From: Jennifer Ballinger
Sent: 08 October 2021 07:55
To: Simone Neat; Emma Whitley
Subject: RE: Bridge House, Wendlebury - 21/02208/F

Change from single glazed to double glazed windows

Replacement porch

GROUND FLOOR PLAN - PROPOSED: 1:100

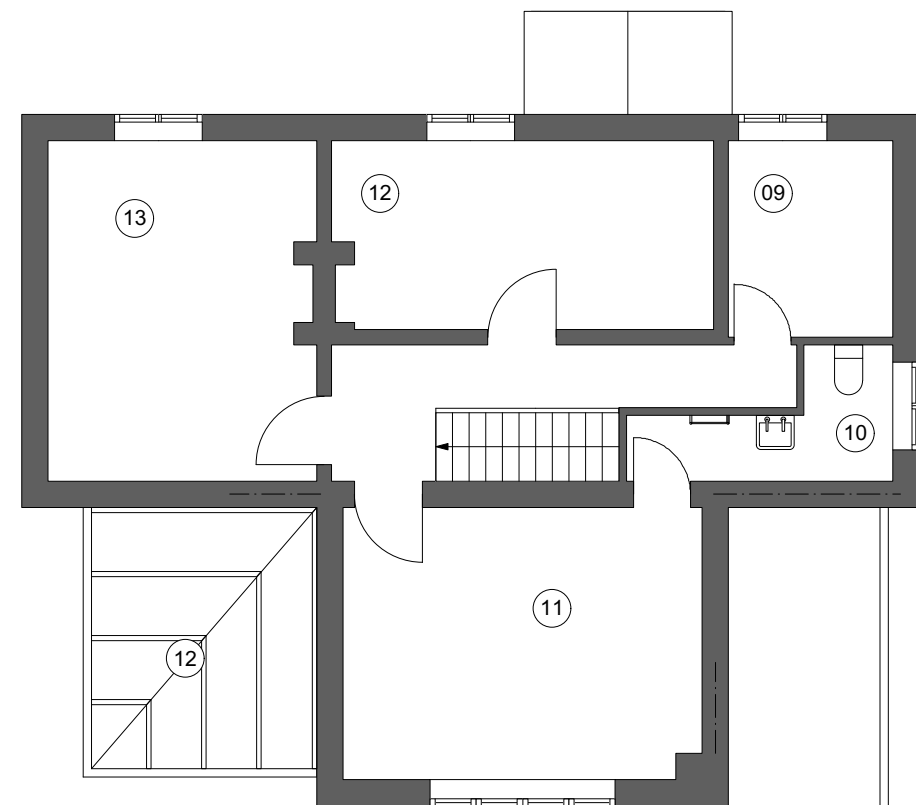
There are no objections to the replacement of the porch, which is identified in the Article 4 study as detracting from the character of the building. There would be the opportunity to enhance the character of the property by erecting a porch of more traditional design and dimensions.

Drawing: Proposed Elevations

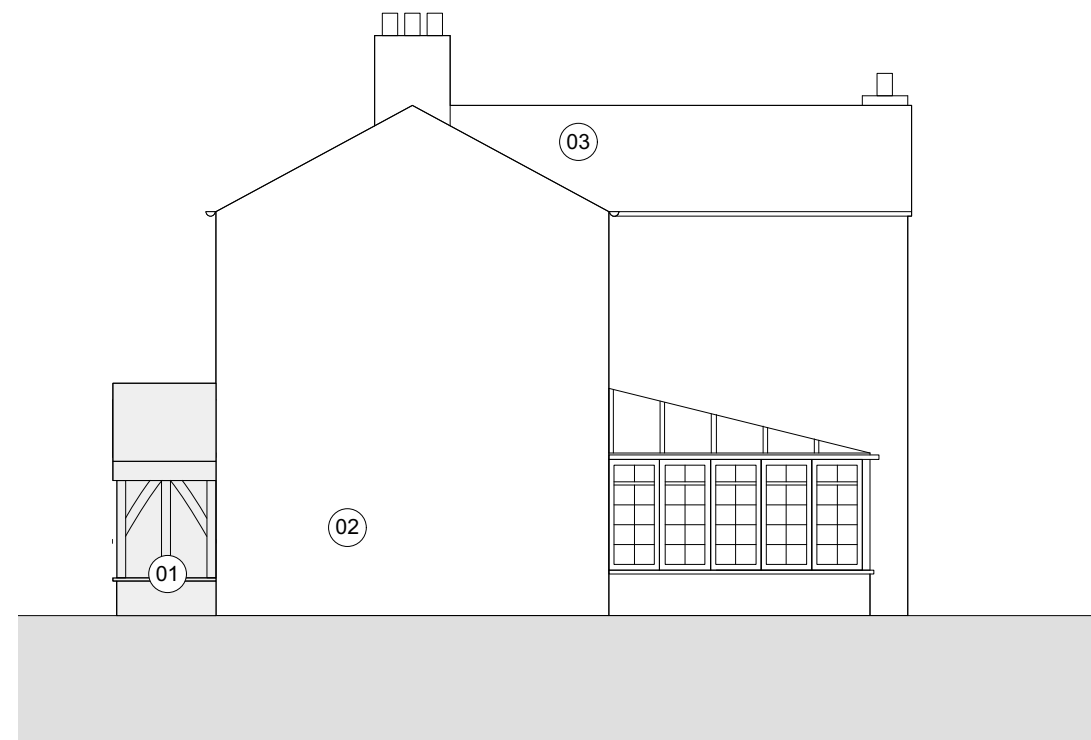
The current windows are modern replacements and are not particularly sensitive to the historic building. There would be no objection to their replacement, but preferably with a more sensitive design. Slim-lite double glazing would be preferable and would provide more traditional profiles to the windows.
